HOTEL BUILDING 2 EXTENSION PLANNING APP

APP NO: 3782 - Erection of a single storey extension to create a spa centre

Tudor Lodge Hotel, 50 Field End Road HA5 2QN

PLANNING RESPONSE MARCH 2023

01 PROPOSED REAR / NORTH ELEVATION
1:200 @ A3

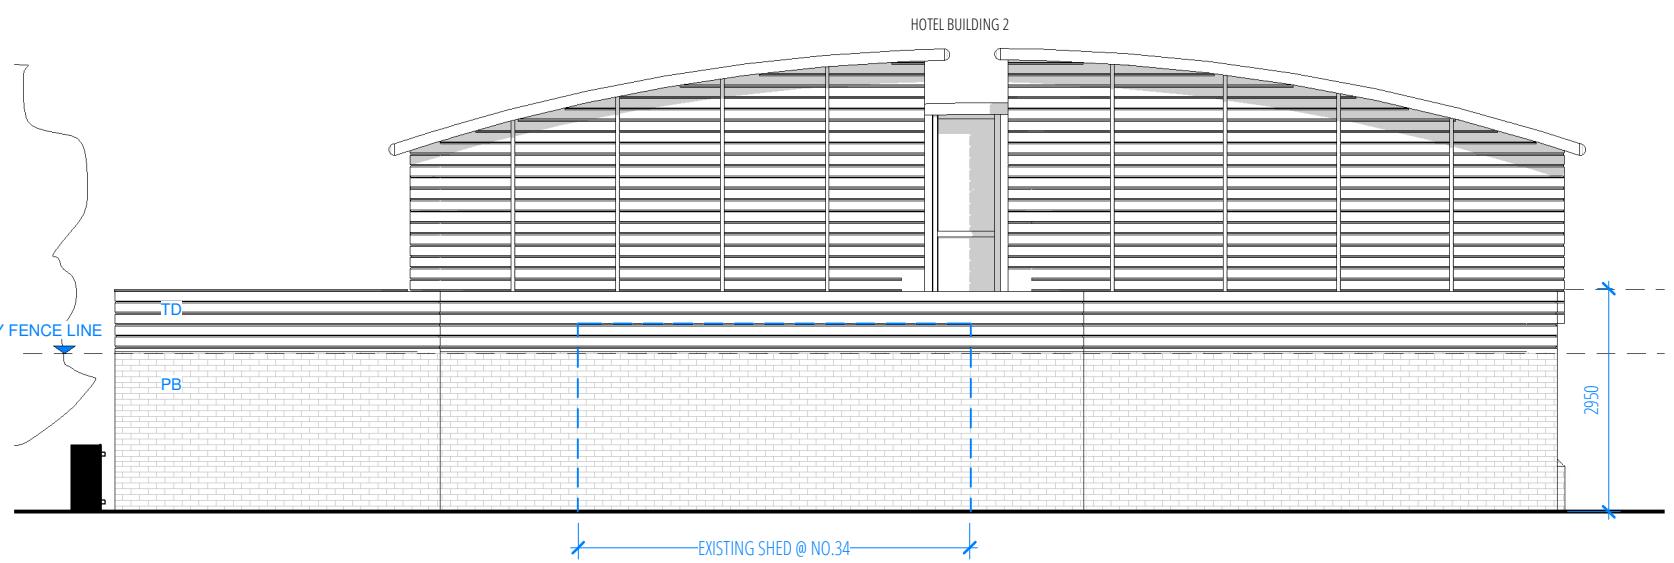
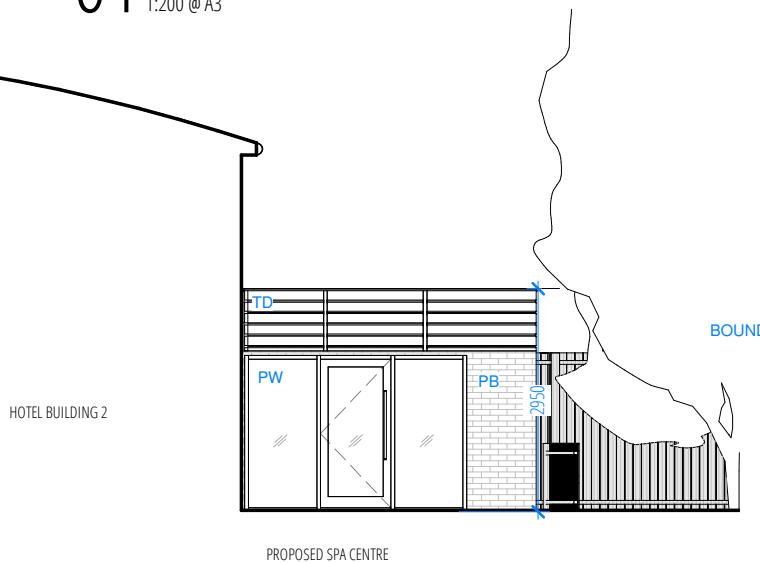
PLANNER COMMENTS: I have issue with the combined issues of the setback from the boundary and the projection forward of what would be the building line as measured to No. 34 in terms of dominance and a departure from the building line

DESIGN RESPONSE: proposed extension is in the same position of existing shed and back up against no.34 side extension. The rear portion of the proposed extension is set back from boundary. The overall extension height is reduced to 2.5 meter with footprint reduced / setback from boundary. The extension entrance design is update to a glassbox design (photo 1). The extension is hidden away from view as shown in photo 2.
